Application no: H01-0800-11

Description: Residential development - erection of two single-storey dwellings (re-submission of H01-1020-10)

Location: 55 Backgate
Cowbit
Spalding
Lincs
PE12 6AP
PE12 6AP

Amendment: Revised access/layout (Dwg no. 1971-02B)

1971 - 02B

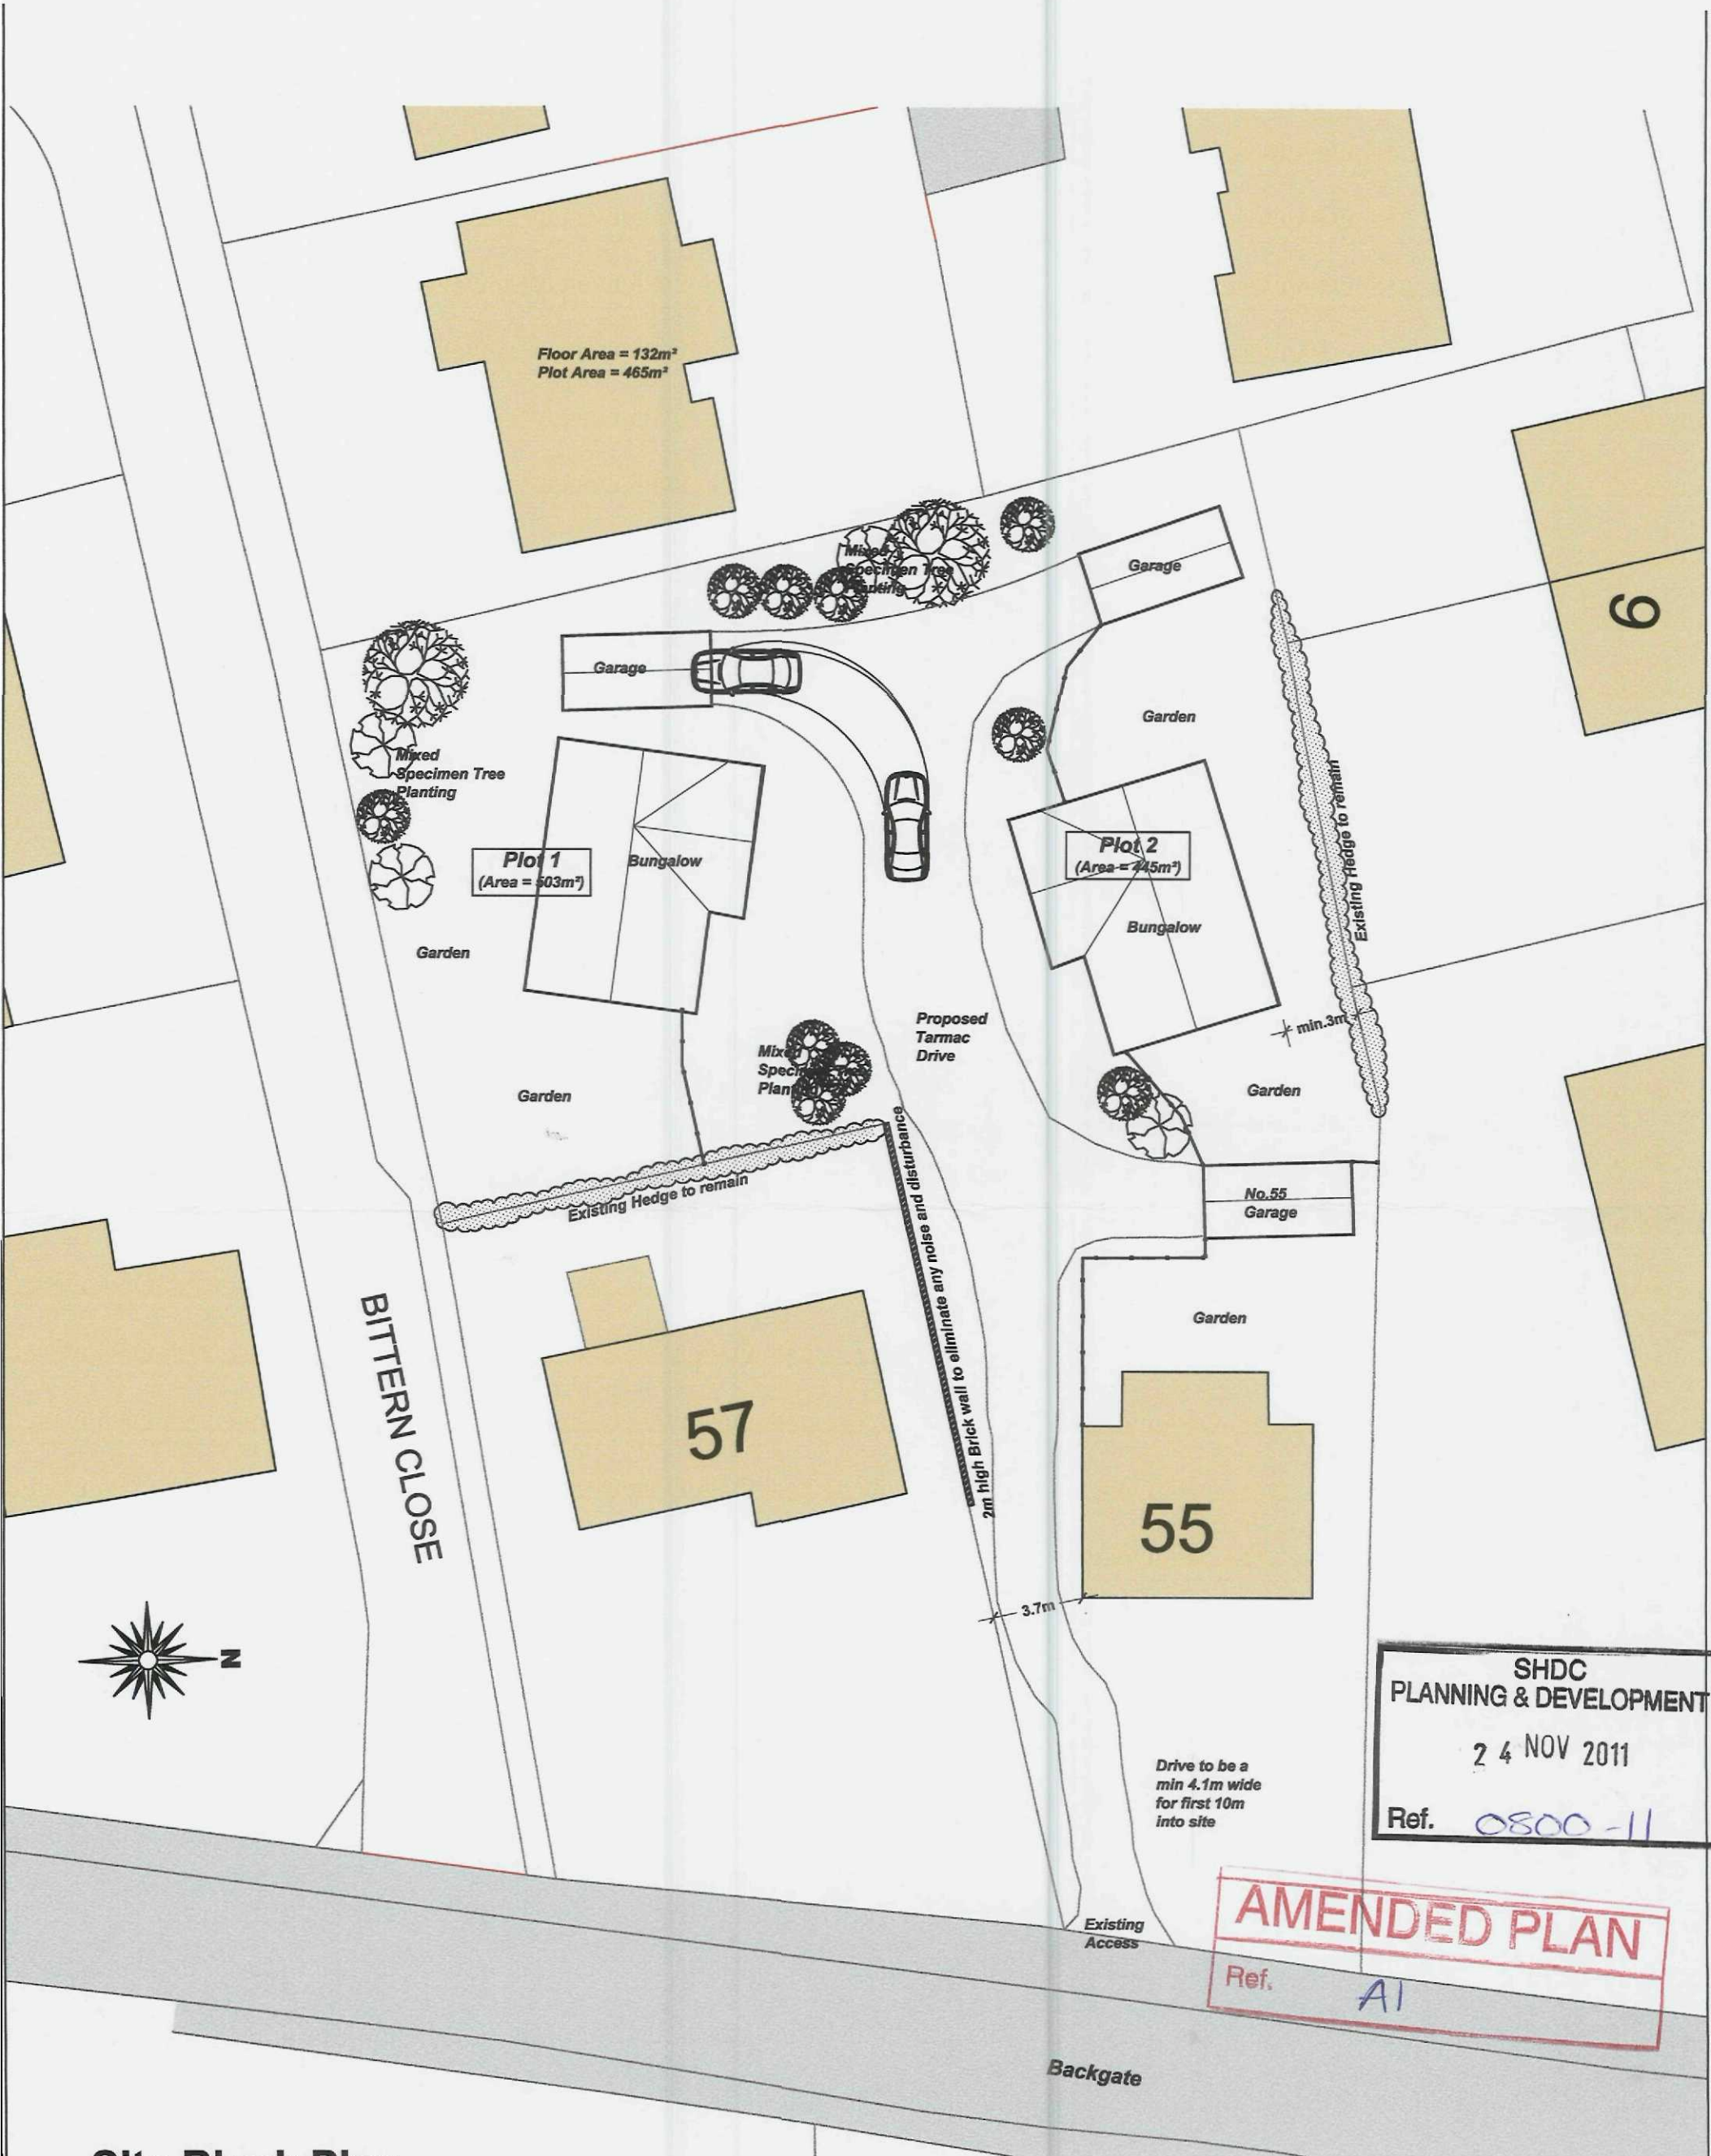
This latest layout looks like it's an improvement over the previous scheme. I would suggest the following however: Plot 1, move the bungalow another 2m north to improve the relationship with No.57. Plot 2, move the bungalow away from the east boundary so that it is set off by a minimum of 3m at its closest point. The single garage to No.55 should have its gables facing east-west to reduce its impact on occupants of No.55.

There's no turning space either- how will this be handled? The area in front of the garage to No.55 would be more than likely to end up with a car parked on it.

I have amended the layout to overcome your concerns as shown on attached drawing.
